Consultation Response from KC Lead Local Flood Authority
2019/90502 Land off, Fernside Avenue, Almondbury, Huddersfield, HD5 8PH
Erection of 10 dwellings
Date Responded:
14/03/2019
Responding Officer:
Aleksandra Tomczyk
Responding Ref:
0
Summary

Title: **Below Ground Drainage Layout**

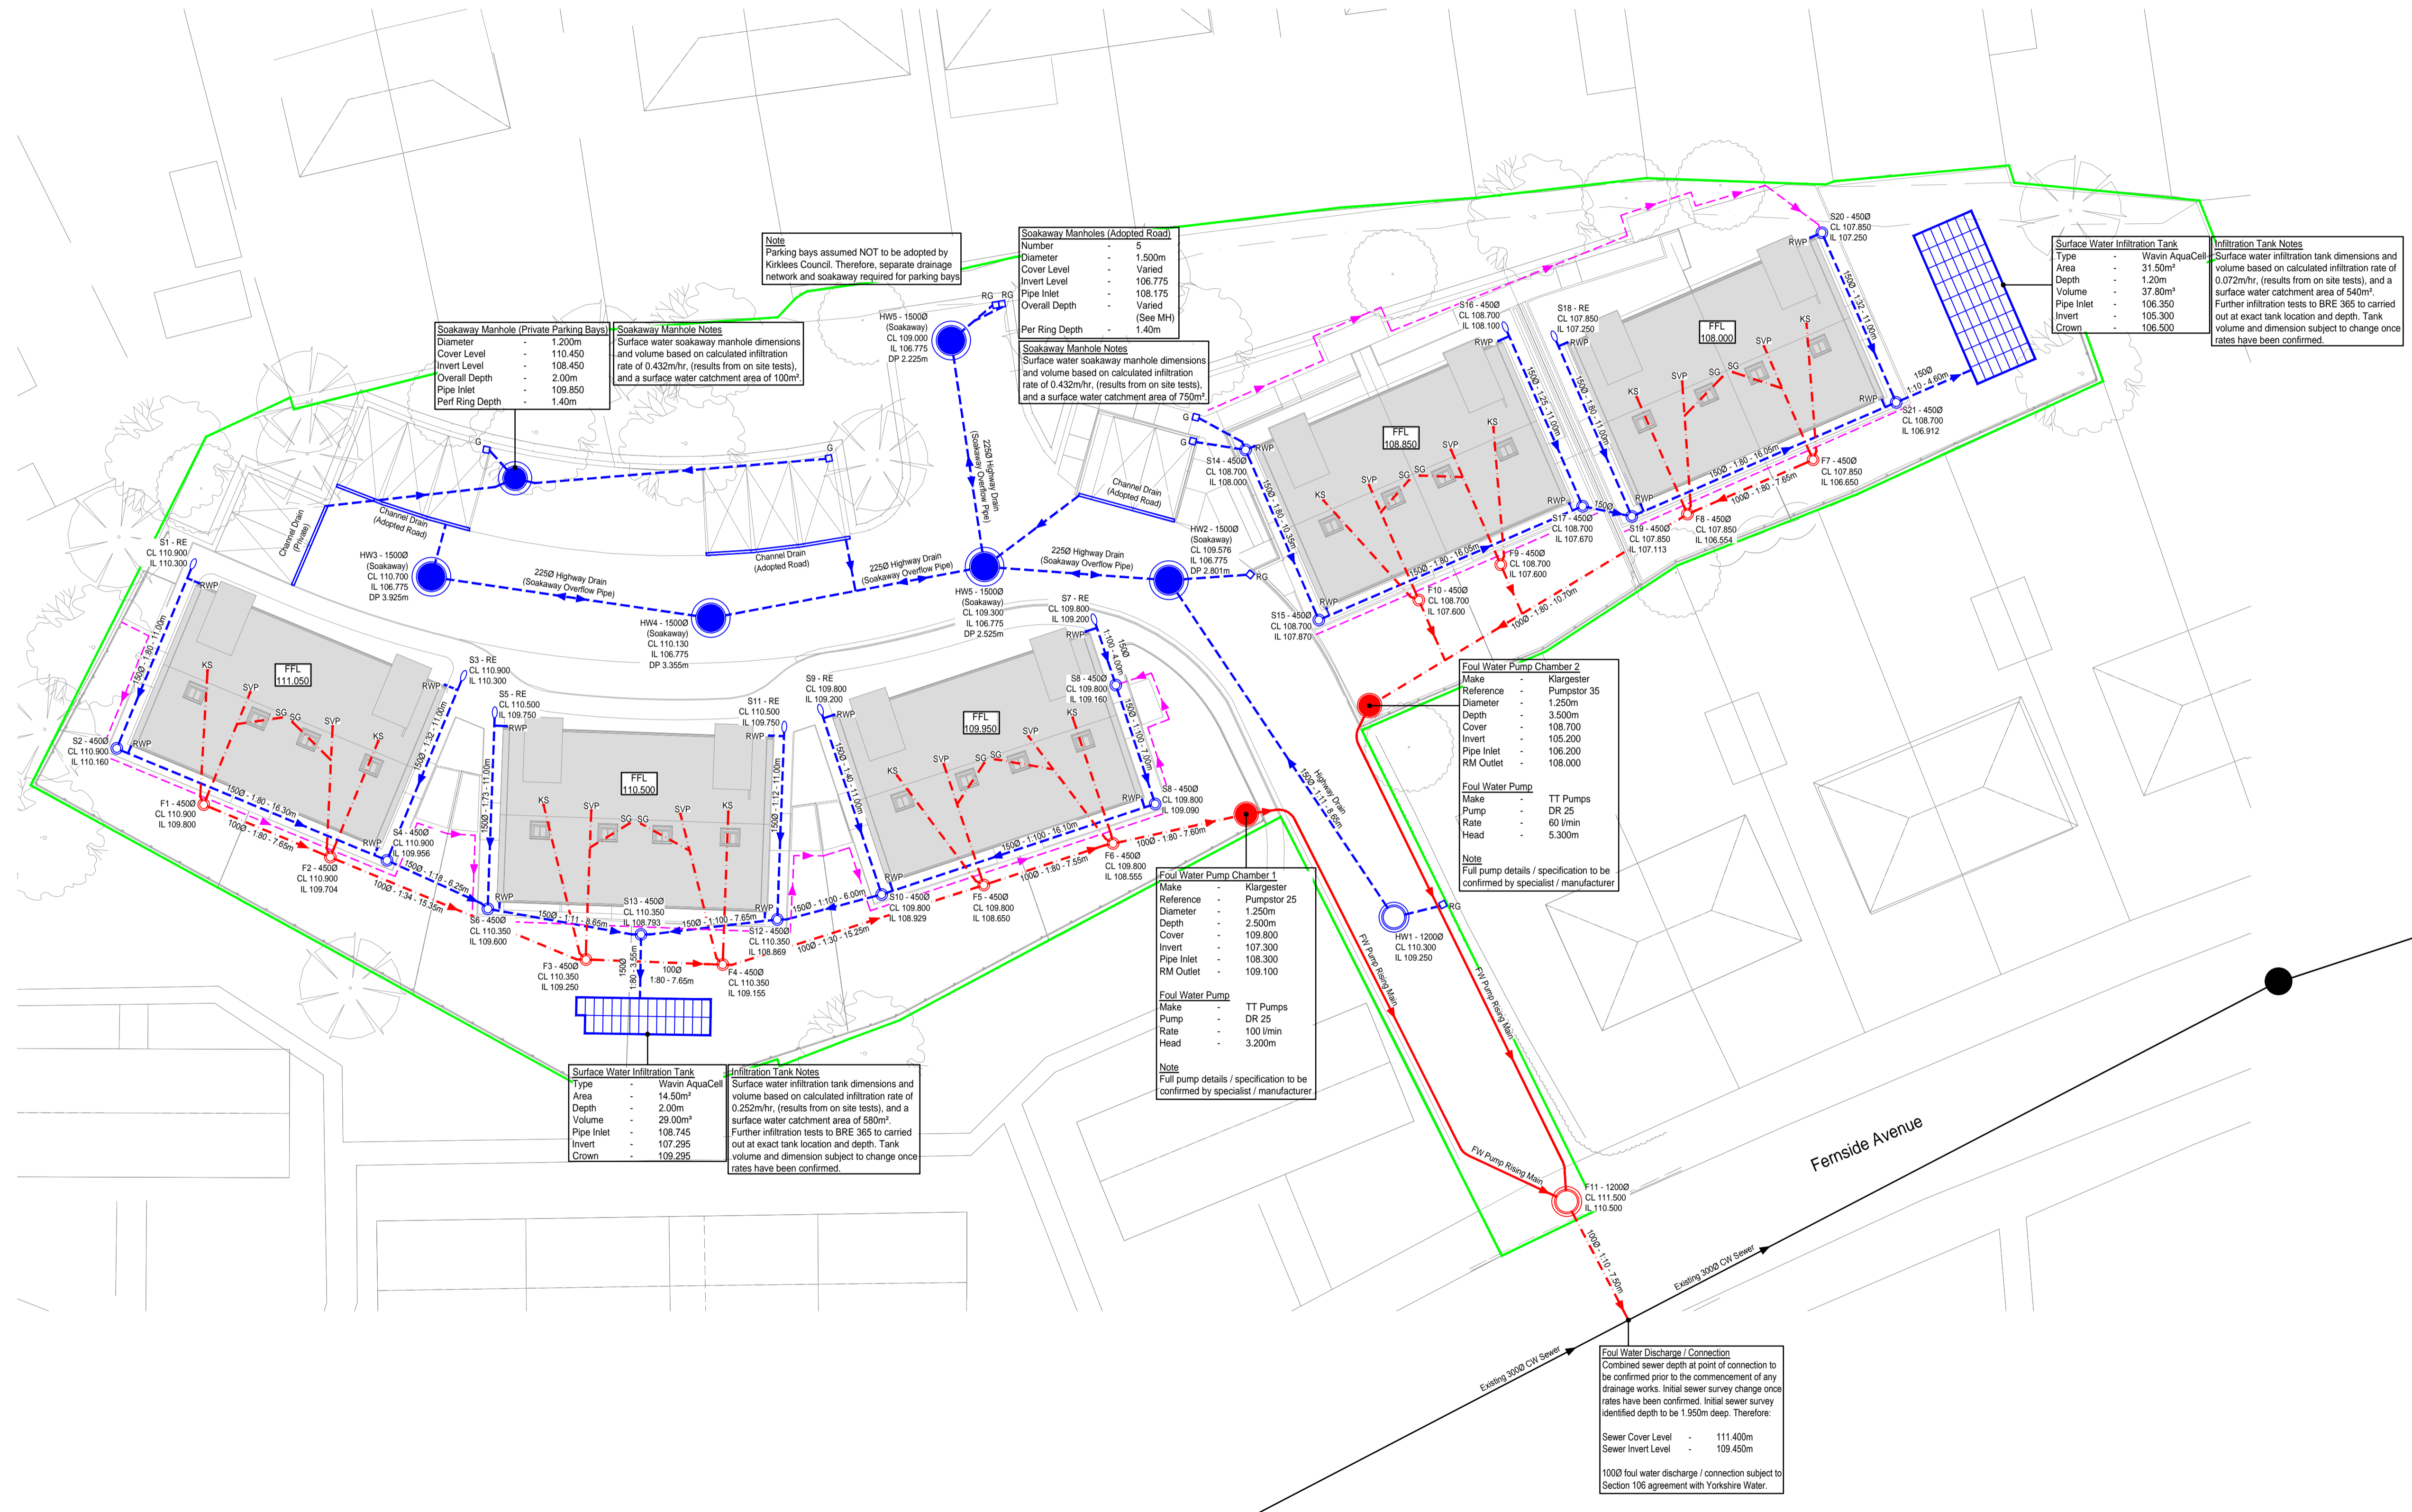
No indication of impermeable areas or surface water discharge rates was given. The applicant should provide calculations to show the proposed discharge rate.

No proposals for surface water discharge point were given. This should be assessed using the following hierarchy of preference:

- Infiltration – this is the preferable way of discharging, unless it is proven not to be feasible in the location. Our maps show that this location has potential to be compatible with infiltration SuDS. The applicant should carry out infiltration testing (according to BRE Digest 365) in a location indicative of soakaways proposed, and let that infiltration rate dictate the sizing of the features.
- Watercourse – our maps do not show any suitable watercourse in proximity to the proposed development site.
- Sewer – if the infiltration is proven not to be suitable or sufficient, surface water can be allowed to be discharged into a sewer. Our records show that there is a combined sewer along Greenside Avenue.

Additionally the applicant should calculate and specify the attenuation sizing, as well as a flow path from the attenuation feature, in case of exceedance event.

A flow path through the development should be considered and presented.
